CITY OF ALBUQUERQUE

October 4, 2021

**Re: Apple Canyon Gourmet – 1301 Cuesta Abajo Ct NE
Erosion and Sediment Control Plan for Demolition
Engineer's Stamp Date: 9/27/2021 (D16E002H)**

SHEET NO.  
C-101

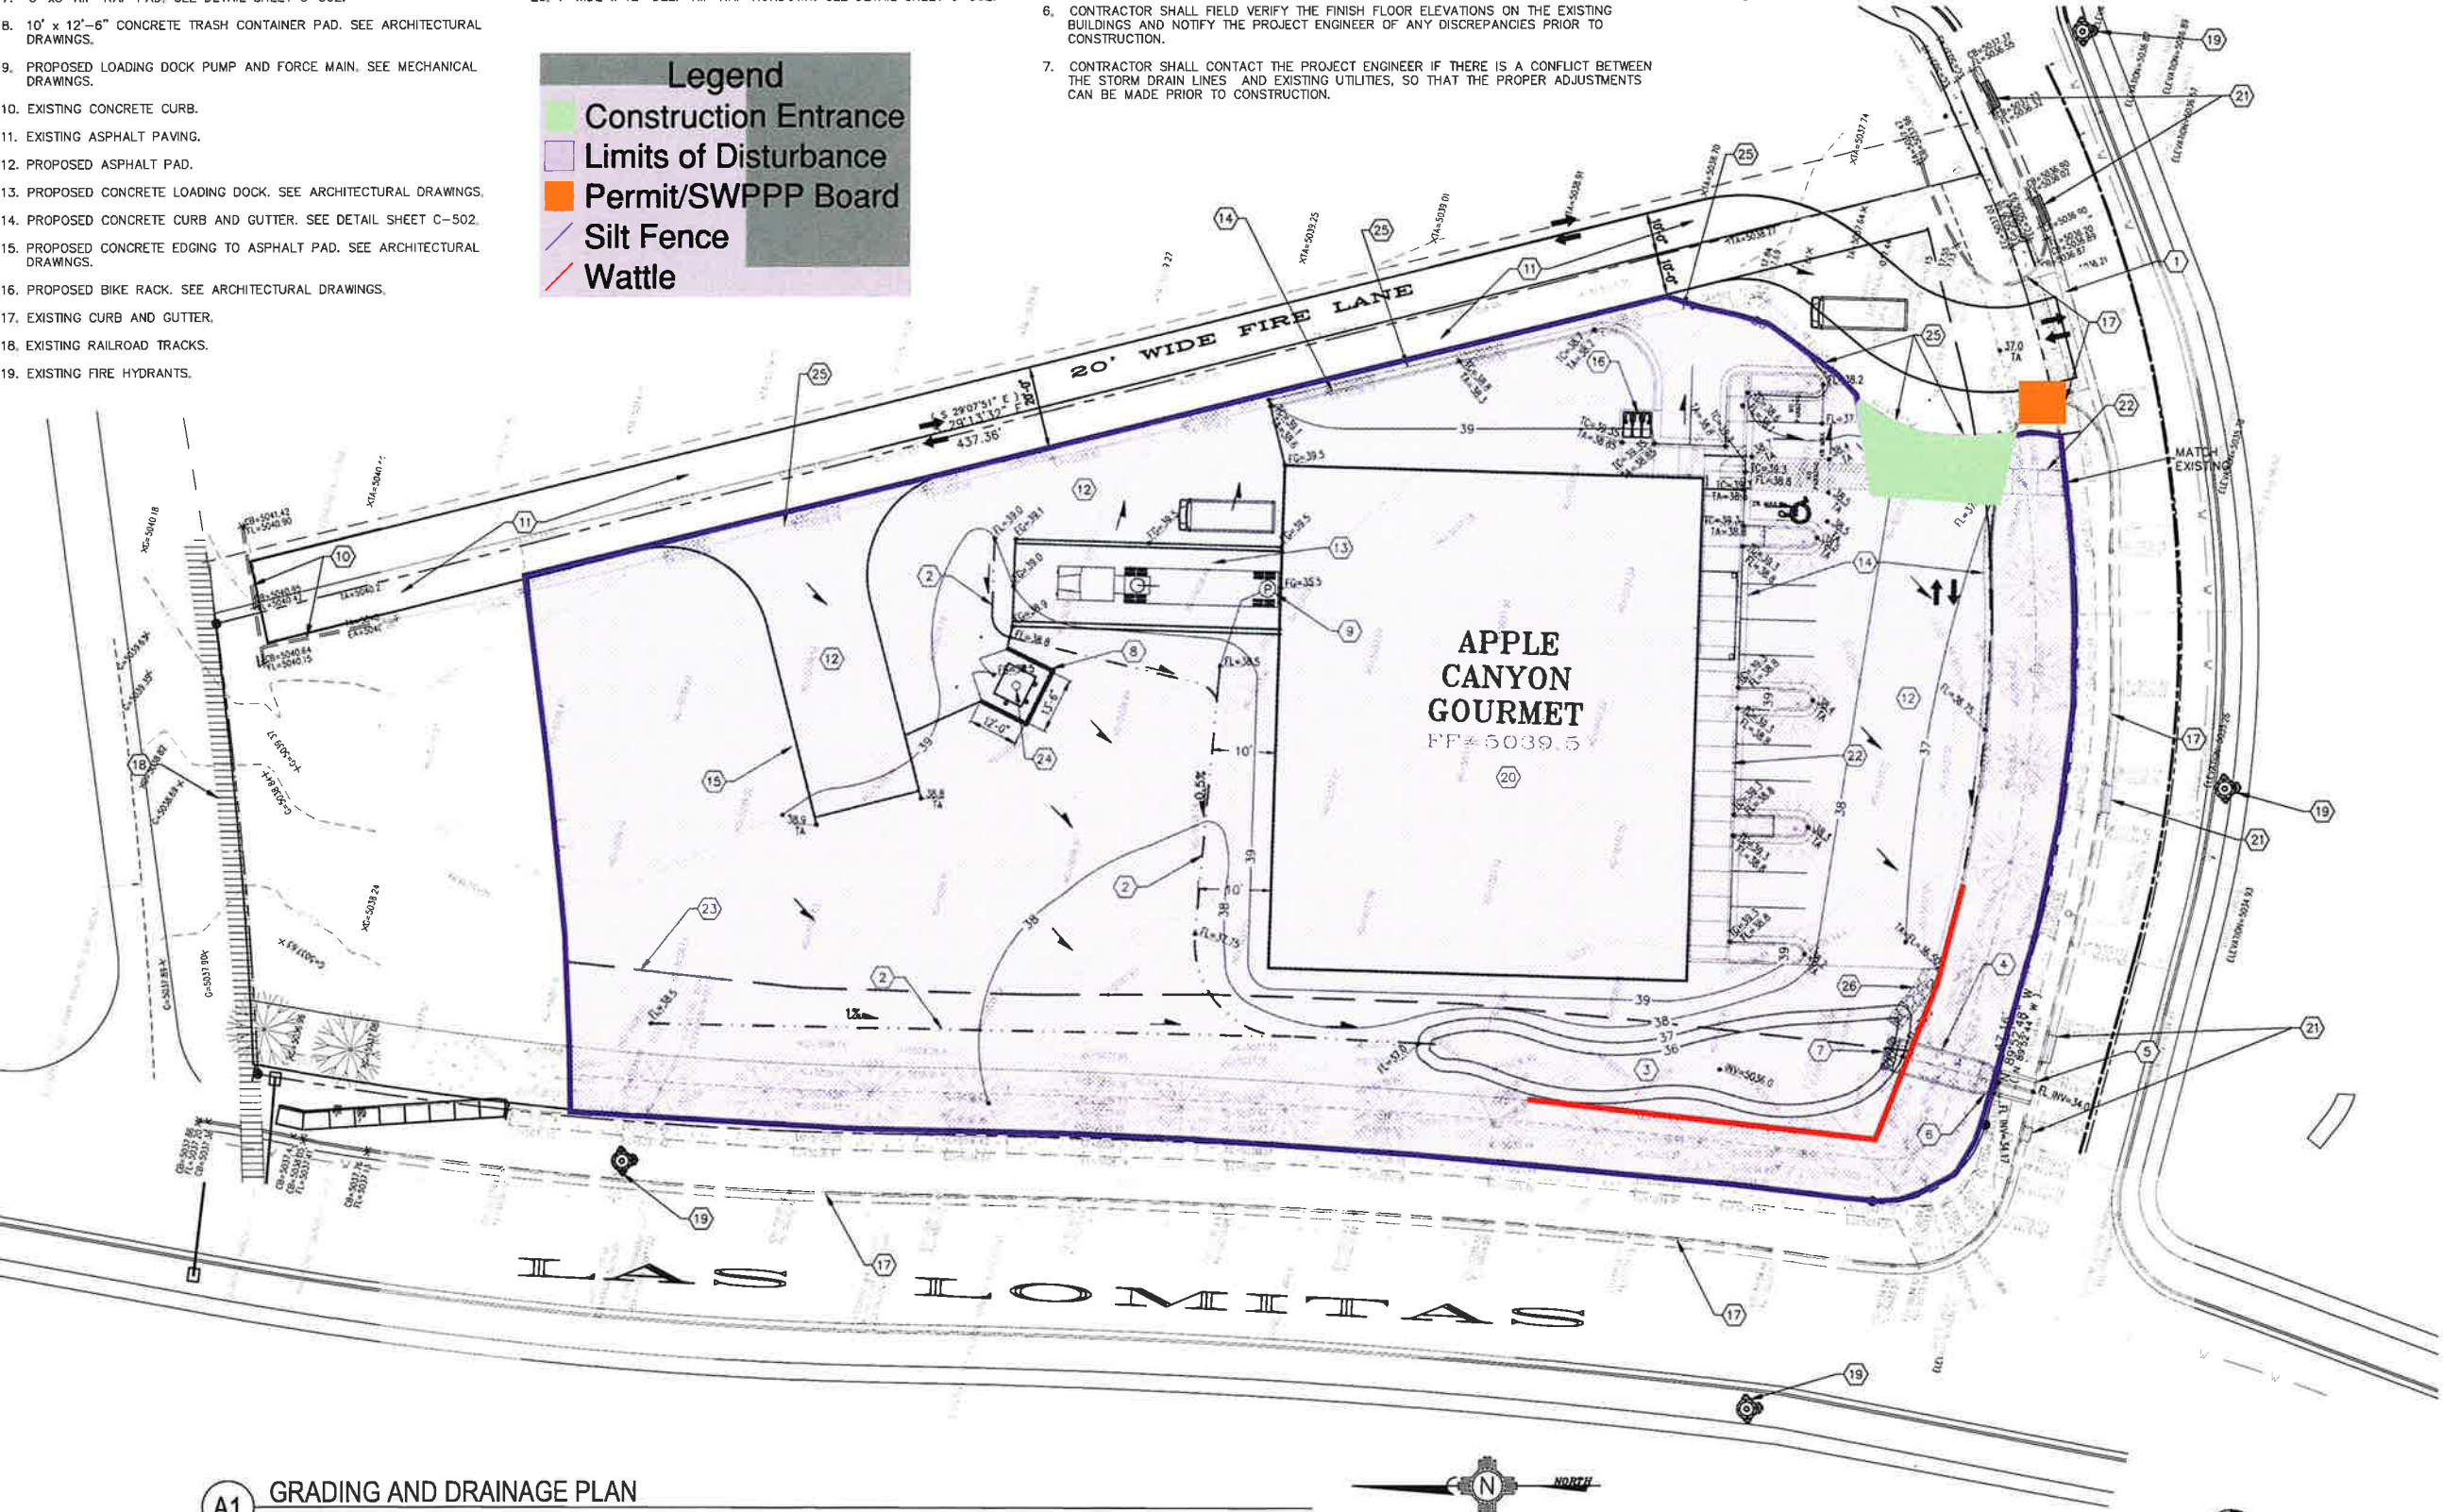
1. Vicinity map – add a zone atlas map clearly indicating location and street names.
2. The limits of disturbance must be shown. It is unclear. Does it include landscaping the area between the sidewalk and the street? Can the area of land-disturbing activities be reduced to less than one acre? (CGP7.2.4.b.i);

3. The existing and proposed grades must be shown on the plan, and they must agree with the Grading Plan approved by Hydrology (CGP7.2.4.b.ii);
4. I can't tell the difference between building, sidewalk, asphalt, and dirt on the ESC Plan. These structures must be clearly identified in the SWPPP per CGP 7.2.4.b.v. The same information is required in the ESC Application. You may include a copy of the Site Plan in both the SWPPP and in the ESC Application to address this requirement.

7. Drainage patterns – Identify locations of concentrated flow paths that enter and exit the disturbed areas. Identify locations where sheet flow enters and exits the disturbed area. Show on-site drainage patterns of stormwater and authorized non-stormwater before and after major grading activities;
